Subject: AB/23/21/L & AB/22/21/HH

17 Maltravers Street Arundel BN18 9AP

(Listed building consent for) New slate roofed porch to rear door, new back door to replace existing rotten door, new insulated roof access window to provide maintenance access to butterfly roof valley, replace broken slates and refix slipped slates, various timber repairs to windows to

Rear Elevation
Existing

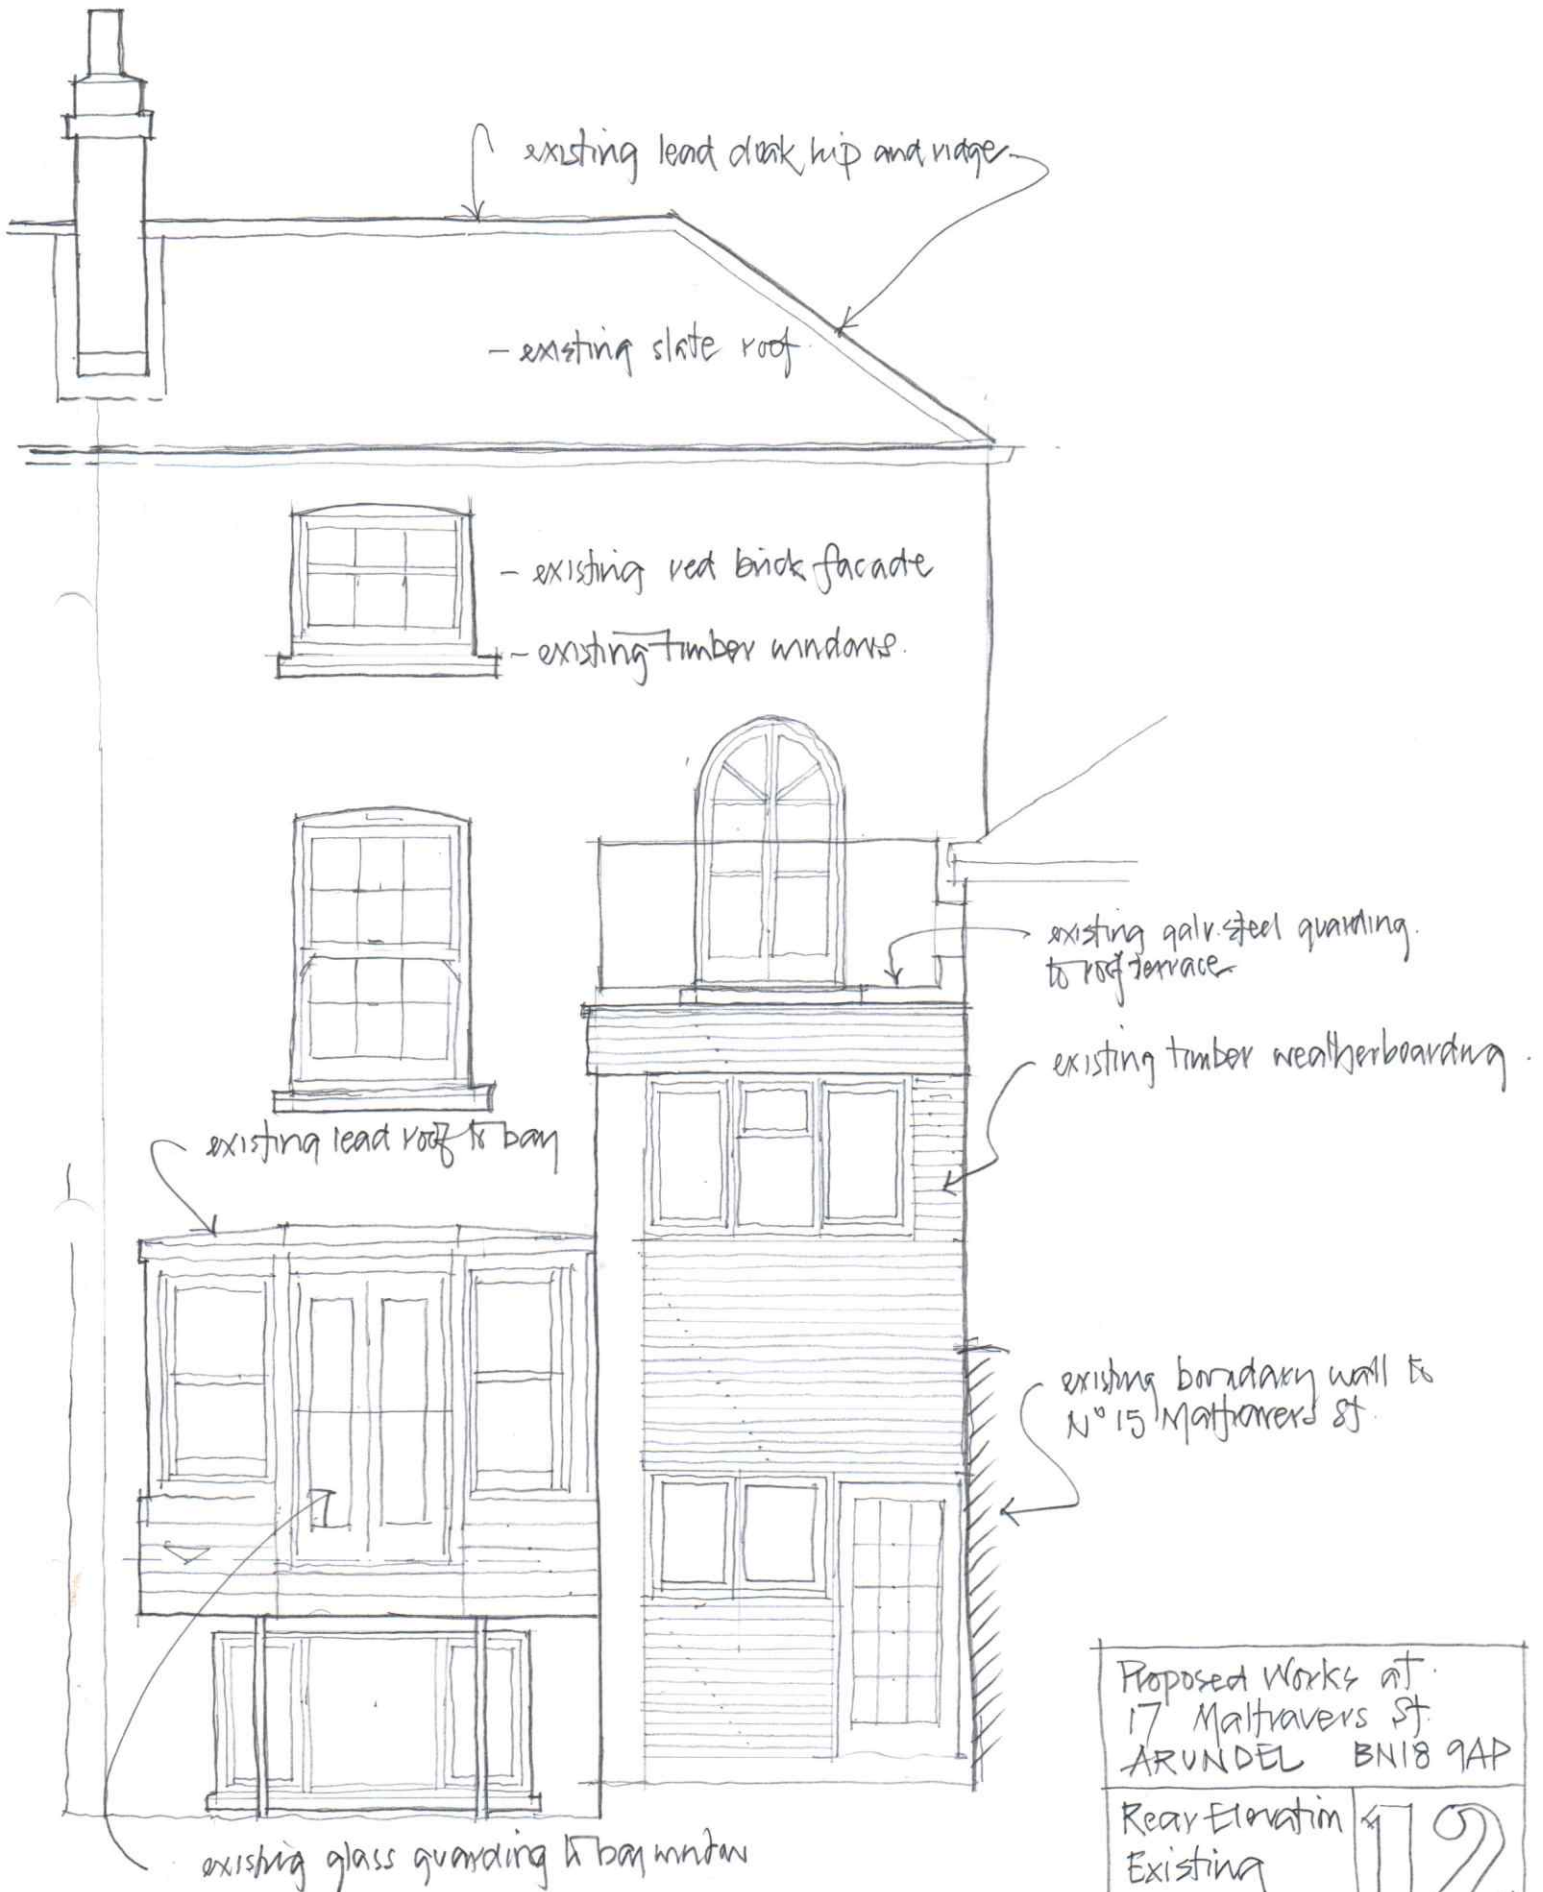
The rear porch is of a scale as to not impact upon the rear elevation and would to some extent help to shield the more recent extension. Appropriate materials are proposed and should reflect those already at the property. I note from the proposed elevation that a new timber door is also required. Whilst this looks to be acceptable, it would help to have further information regarding its appearance, glazing and treatment.

Proposed Works at 17 Malttravers St ARUNDEL BN18 9AP	
Roof Plan Existing.	15
1:50 Feb'21

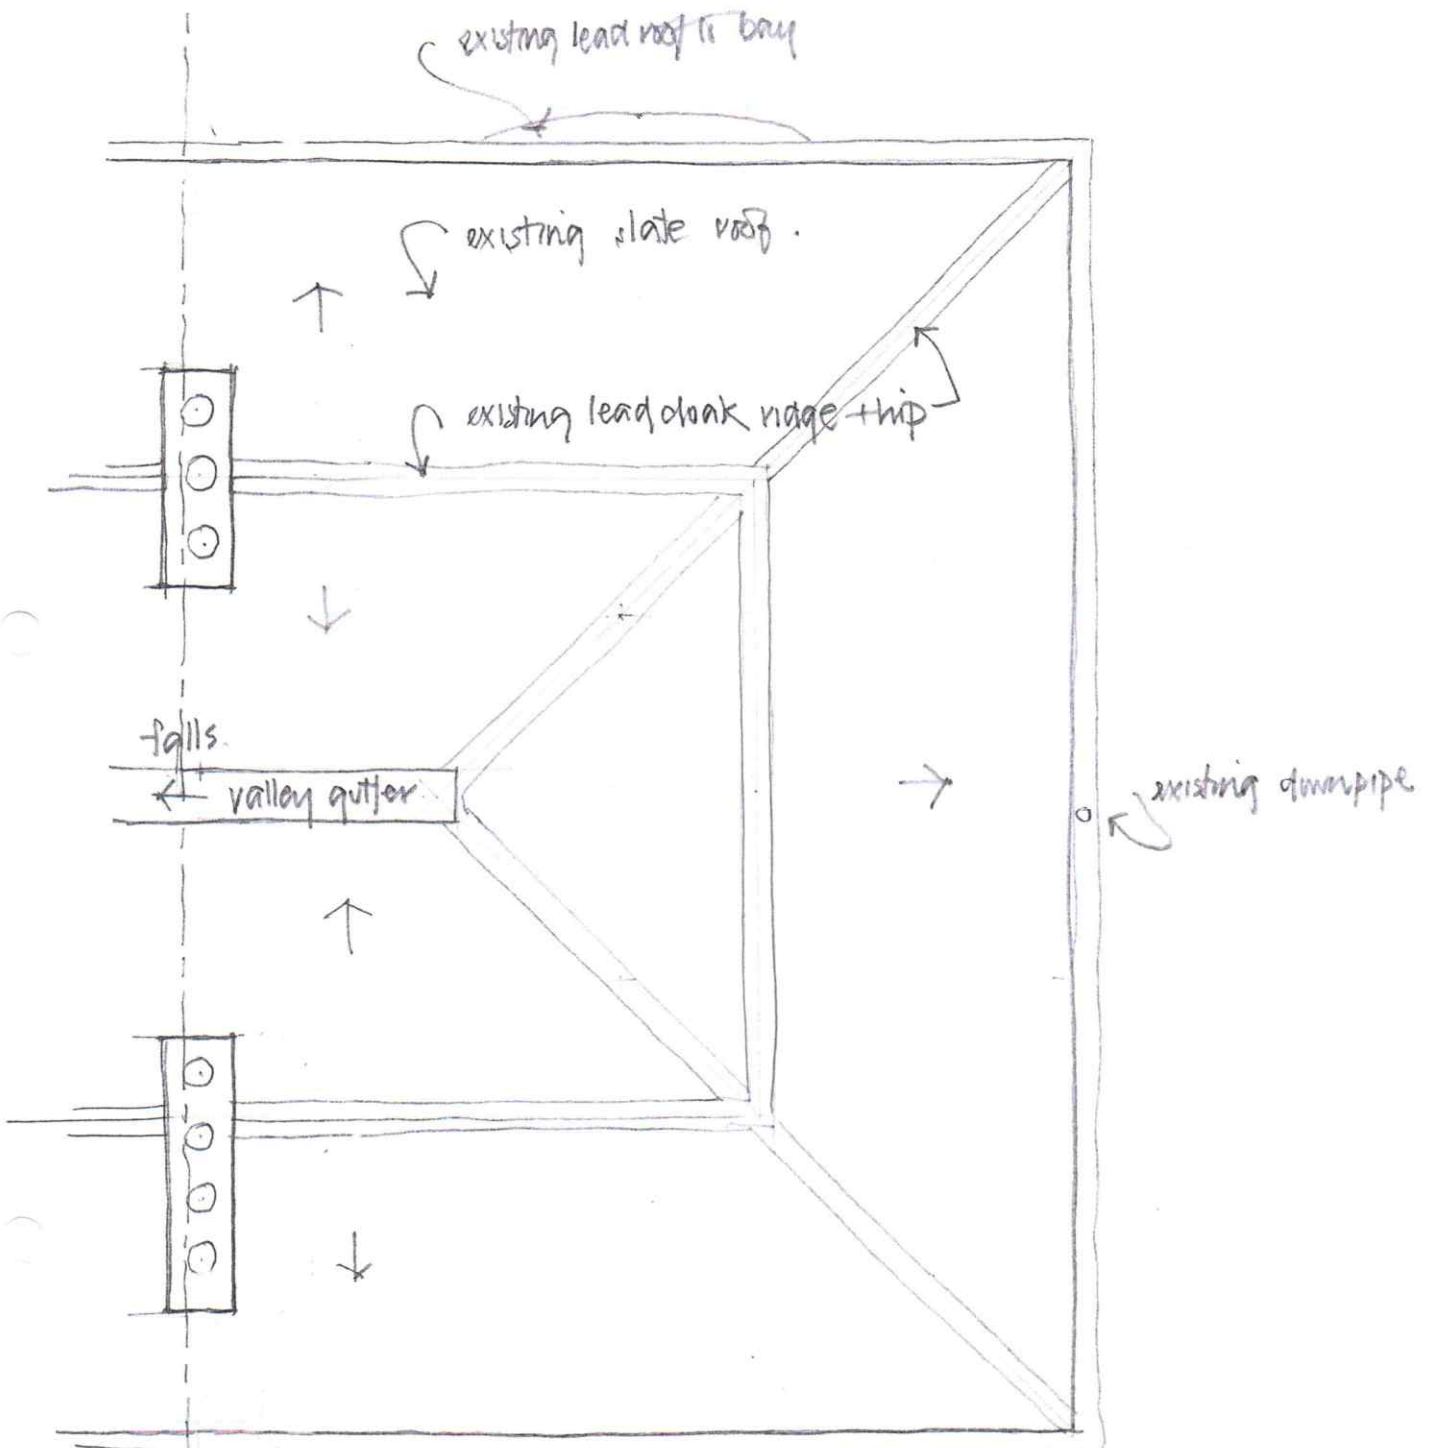
Whilst the proposal appears to include a considerable amount of work, some of the elements are works of repair which will allow the building to remain in a good condition. Whilst this is positive, I would want to be assured that the repointing of the chimney would be undertaken in a sympathetic way so as to not damage any historic fabric. As part of this works should not remove existing pointing using electronic tools and the replacement materials should match the existing in composition and appearance etc. The proposed Velux should also be of conservation standard.
